AQUIND INTERCONNECTOR

Applicant's Comments on Responses to ExA First Written Questions

Document Ref: 7.4.2

DATE: 20 OCTOBER 2020

## Area 2 Kings Pond Meadow

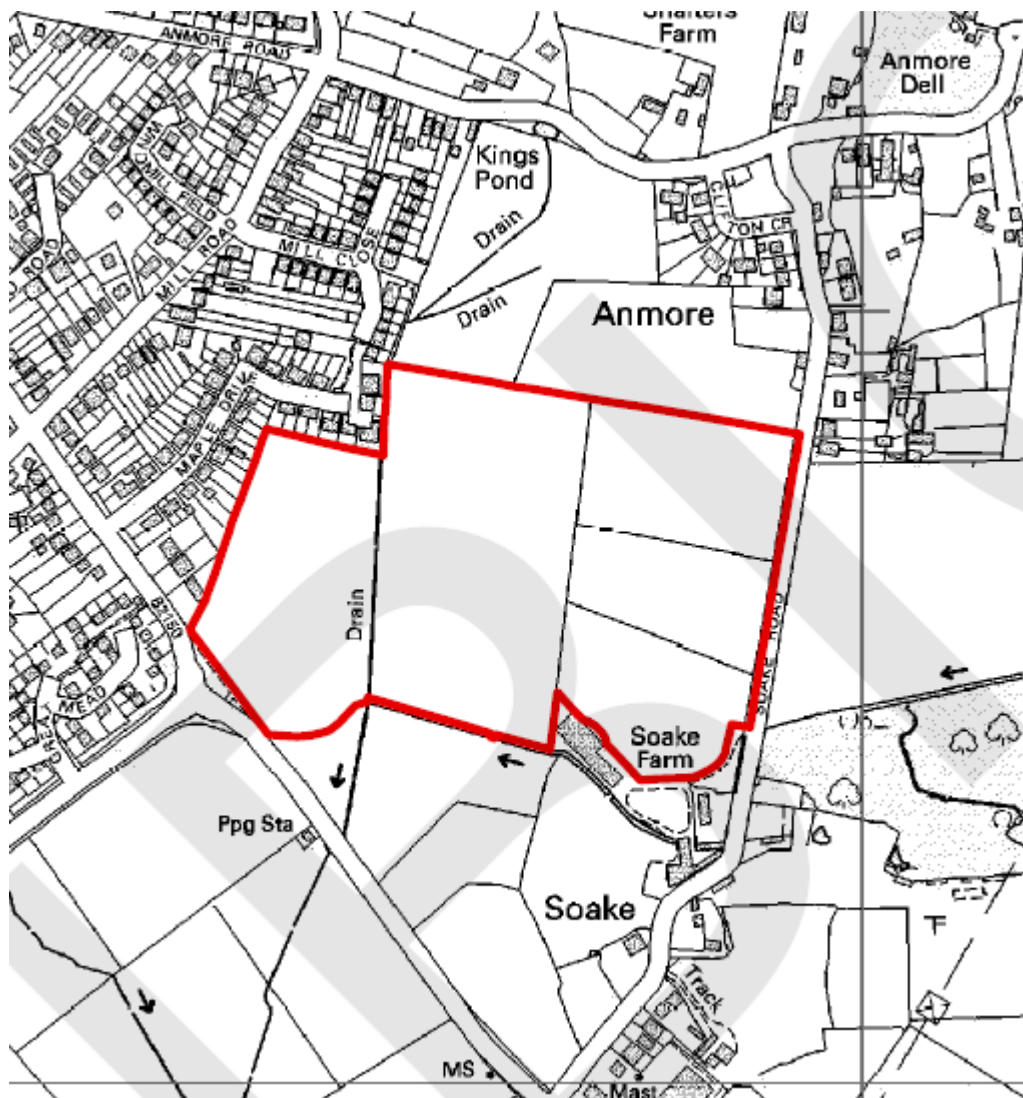
Reference	Written Question	Response to Written Question	Applicant's Comment	Winchester City Councils response at Deadline 3
		<p>the road and then cut back north. In the event one of the circuits does turn eastward, it is not clear on the implications on the Kings Pond Meadow SINC as the cable seek to achieve the bend to enter the road.</p>		
<p>CA1.3.107</p>	<p>For the alternative cable routes shown in the application at Anmore Road (Paragraph 5.3.5 of the Statement of Reasons [APP-022]), what are the Council's views on whether the regulation provided by dDCO [APP-019] Requirement 6(2), together with the addition of an article similar to Article 19(5) and a requirement similar to Schedule 1 Part 3 Requirement 12 at Appendix D of the Examining Authority's Recommendation Report for the Thanet Extension Offshore Wind Farm Nationally Significant Infrastructure Project https://infrastructure.planninginspectorate.gov.uk/wp-content/uploads/projects/EN010084/EN010084-003108-TEOW%20%E2%80%93%20Final%20Recommendation%20Report.pdf would provide sufficient clarity at an appropriate time in respect of the chosen cable route, notwithstanding any other concerns that the Council may have?</p>	<p>It is our understanding that there are two alternatives in play. Either both cable circuits go straight across the road, or on leaving Kings Pond Meadow SINC the circuits split with one going straight across and the other turning east onto the road. If the applicant retains the alternative cable route arrangement then clearly there is a need for the relevant bodies to be notified of the specific alternative to be implemented with all powers associated with the redundant option then extinguished. The wording used in the example quoted seems to cover the necessary elements.</p>	<p>As shown on the updated Land Plans (REP1-011) the section of Anmore Road that allowed the Onshore Cable Route to be split has been removed from the Order Limits. As a result the Onshore Cable Route will be installed directly across Anmore Road. This update has been reflected in the updated Framework Traffic Management Strategy (REP1-068 and 069) submitted at Deadline 1.</p>	<p>Issue resolved.</p>

Aquid Countryside Option

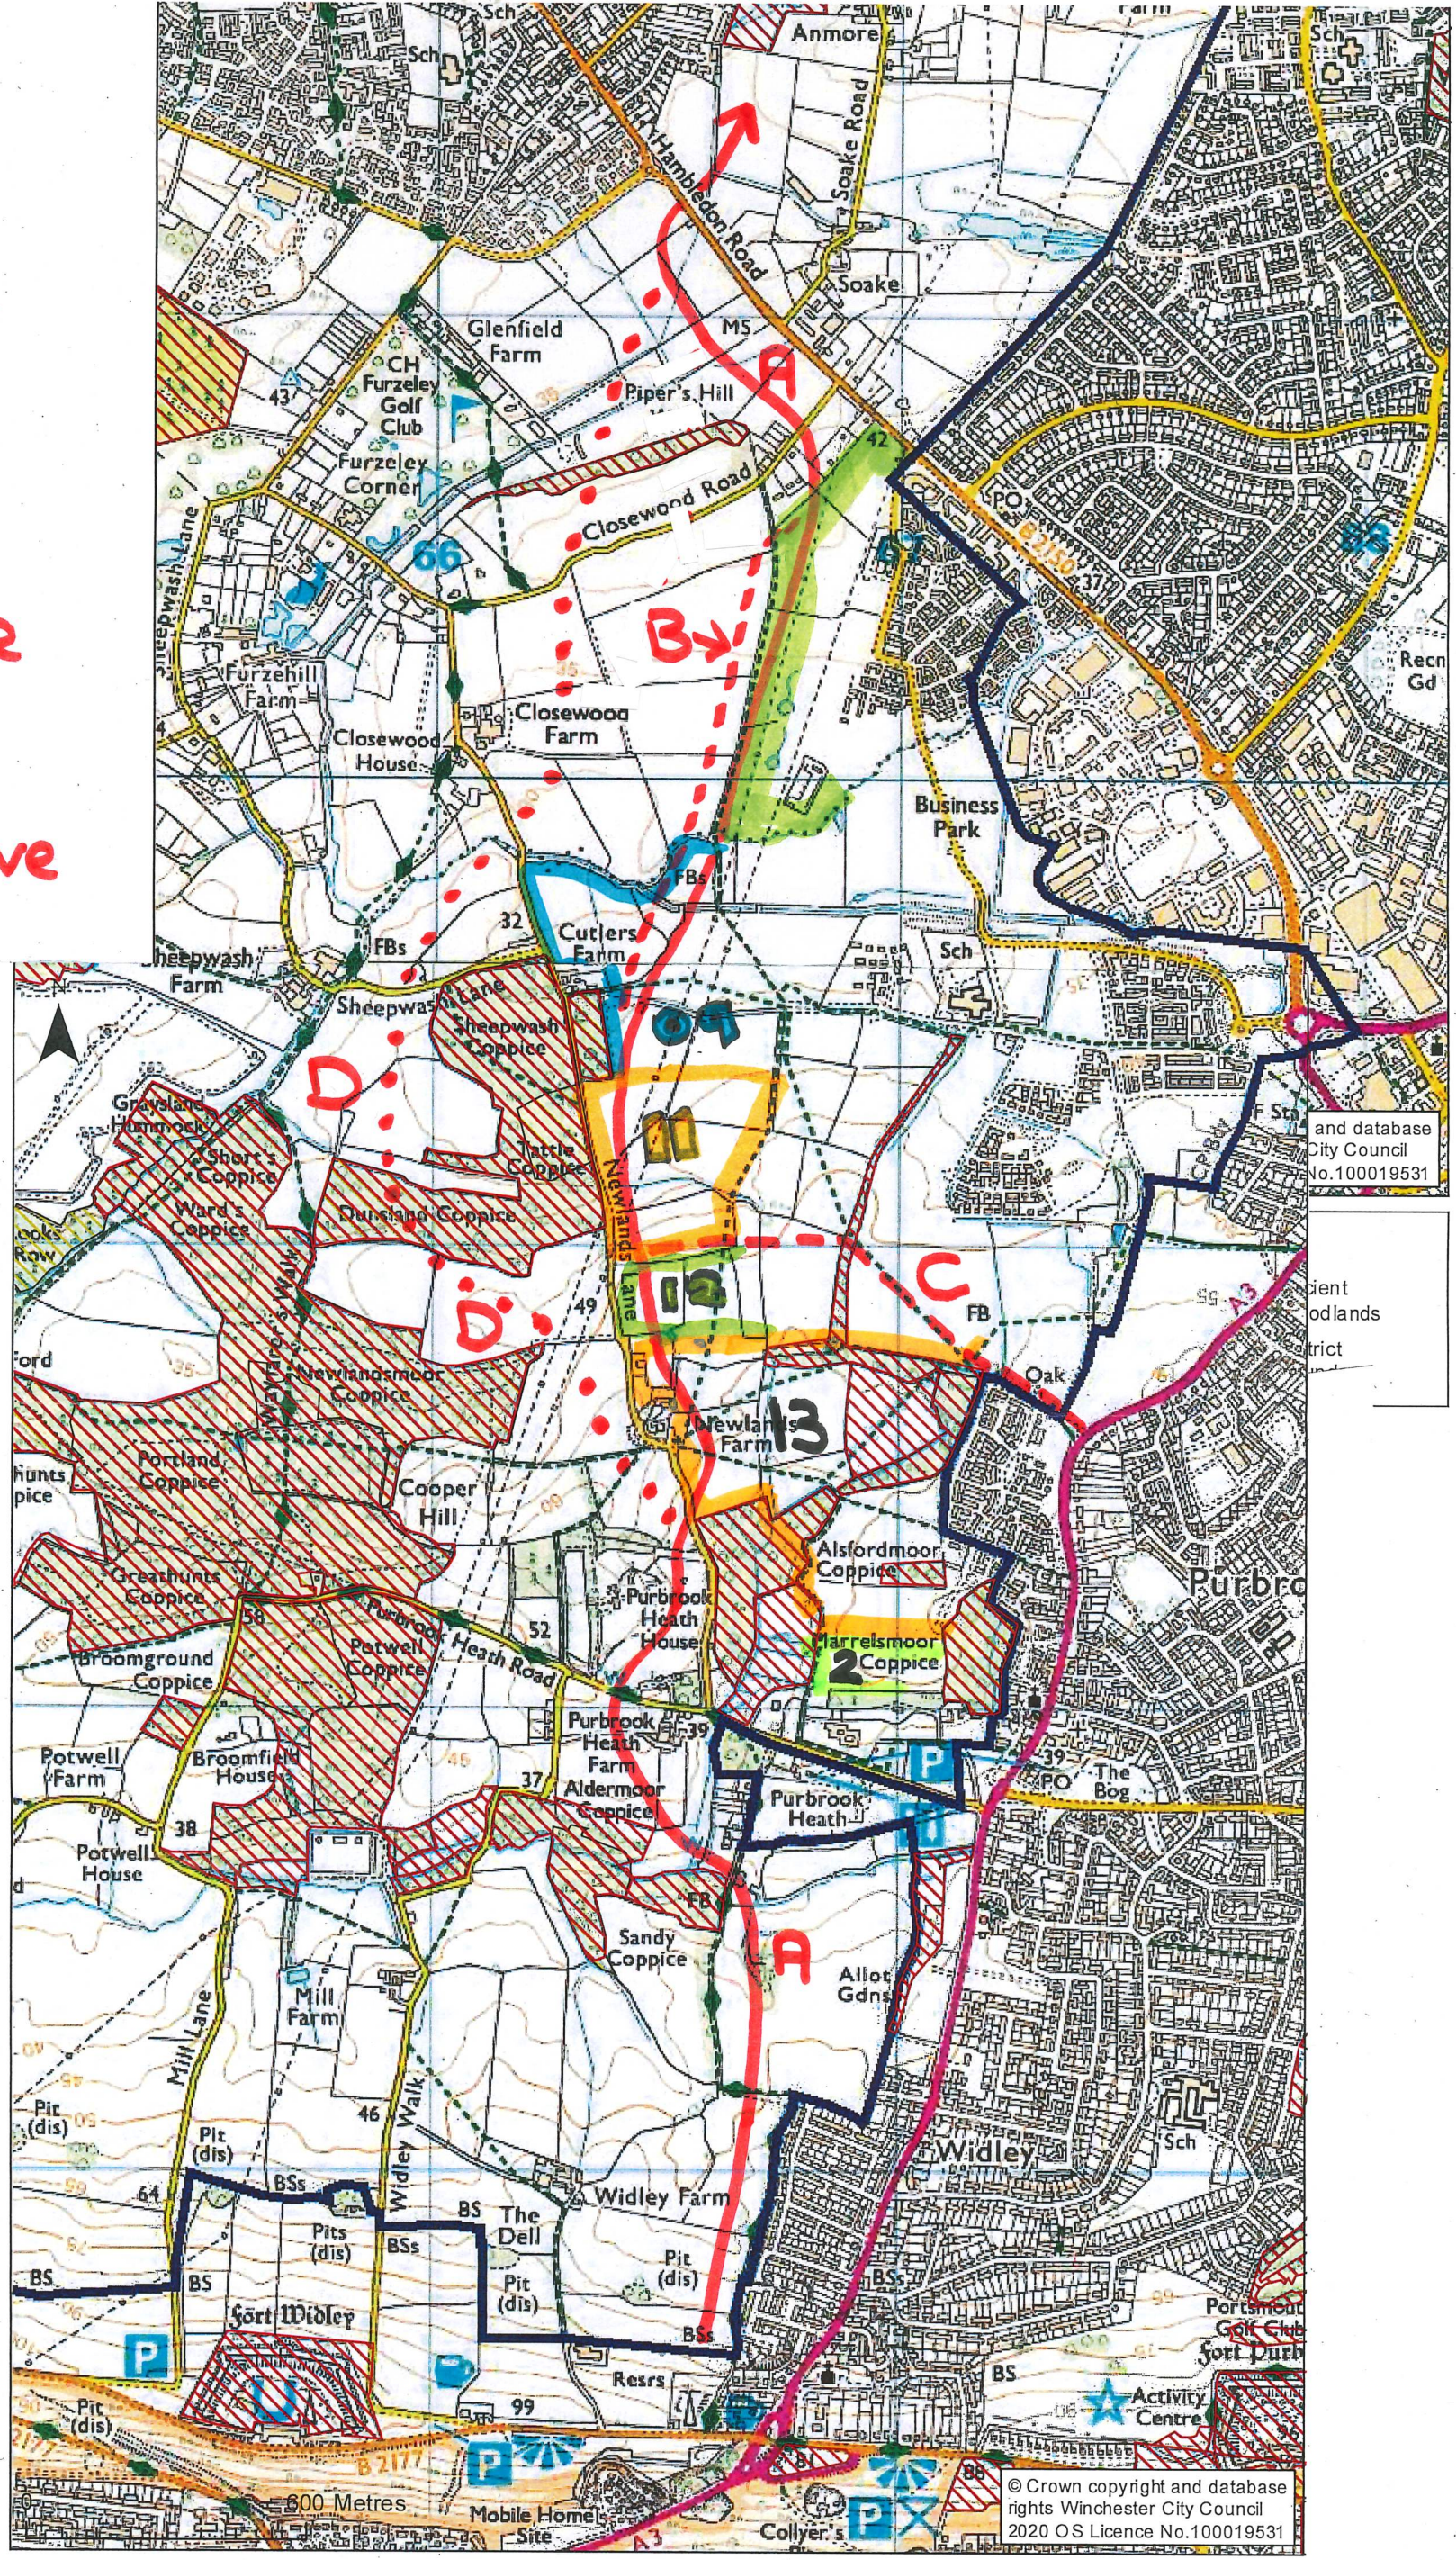
CA1.3.105	For the alternative cable routes shown in the application at Anmore Road (Paragraph 5.3.5 of the Statement of Reasons [APP-022]), which route would the Council prefer to see utilised, or have the least objection to, and why?	WCC has addressed this matter in its LIR section 4.6.5 & 4.6.16 The Councils preference would be for both cable circuits to go straight across Anmore Road, through the section with the pallet fence on the roadside boundary. This is with the absolute proviso that the TPO tree and its root system are not harmed and adequately protected. This route is more direct, it reduces the closure time of the road, has less impact on residents and avoids the loss of any hedgerow that would result if one of the circuits went partly along	The Applicant has provided a response to the WCC LIR at Deadline 2 (document reference 7.7.13).	The proposal has been revised, on leaving Pond Meadow the cable route will now go directly across Anmore Road. Consequently this issue has been resolved.
